13 May 2020

Thank you for the invitation to comment again on 42 Honeysuckle Drive.
The following comments relate to the most recent SSDA - 10378

Rory Toomey
Principal Design Excellence
GANSW

Figure 7 – Equinox March 21 (Bates Smart pg. 52)

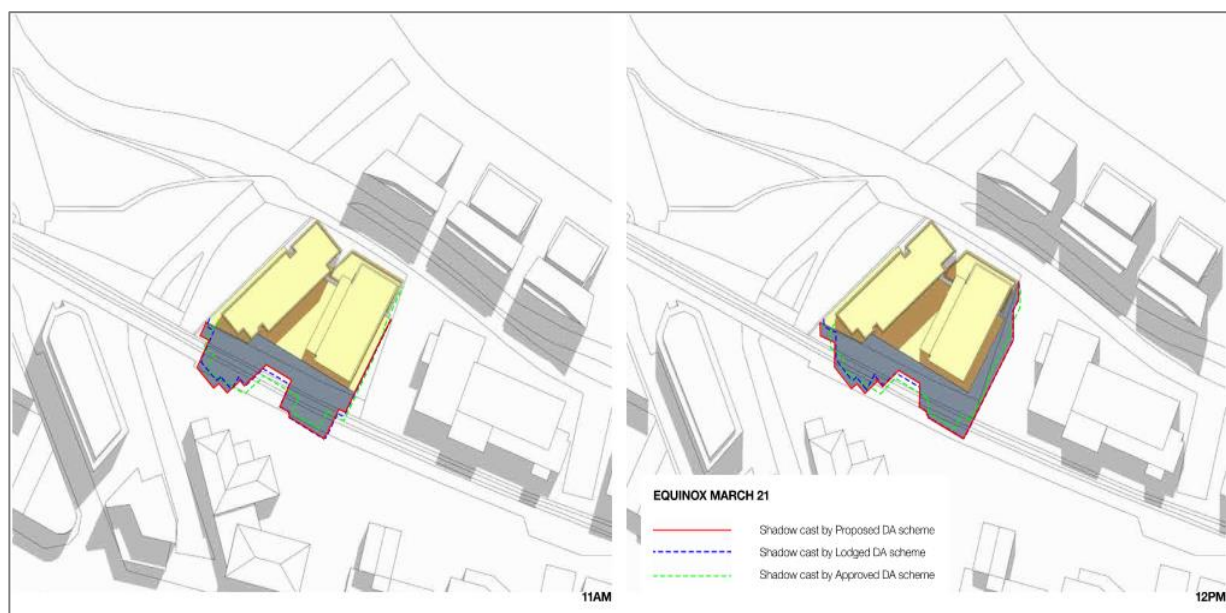
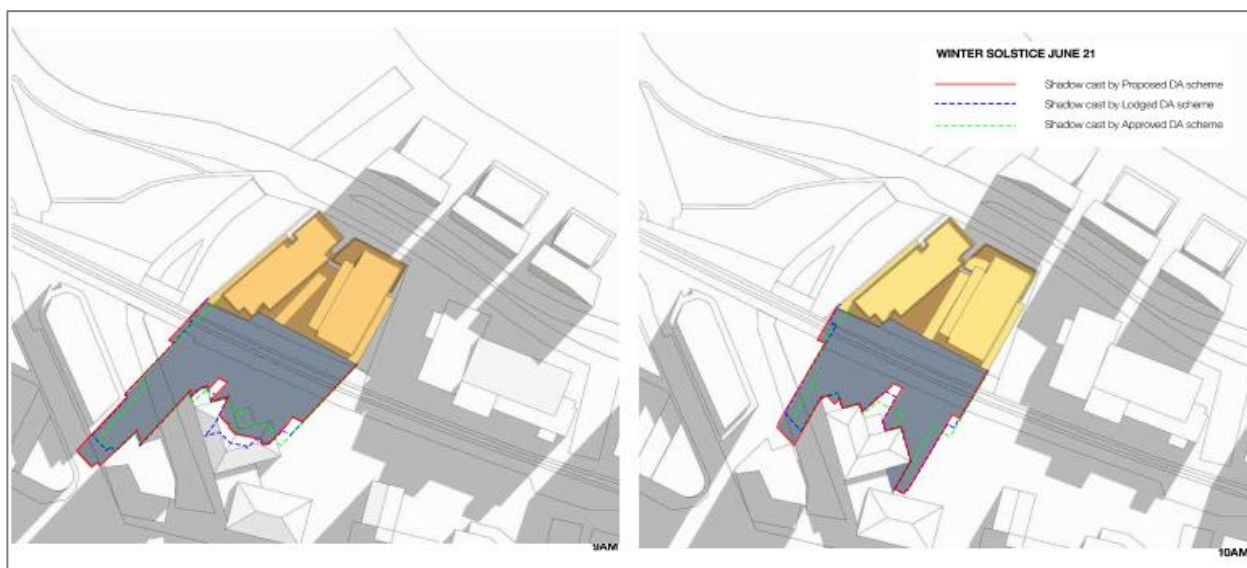
We suggest the applicant be asked provide clear solar access studies showing the shadows cast by the previously approved scheme with height to RL 32.820 in comparison to shadows cast by the currently proposed scheme with height to RL 41.330

A redistribution of mass away from the southern parapet may be necessary to preserve solar access to the neighbouring site to the south. We look forward to an opportunity to review the solar comparisons prior to making any further recommendations.
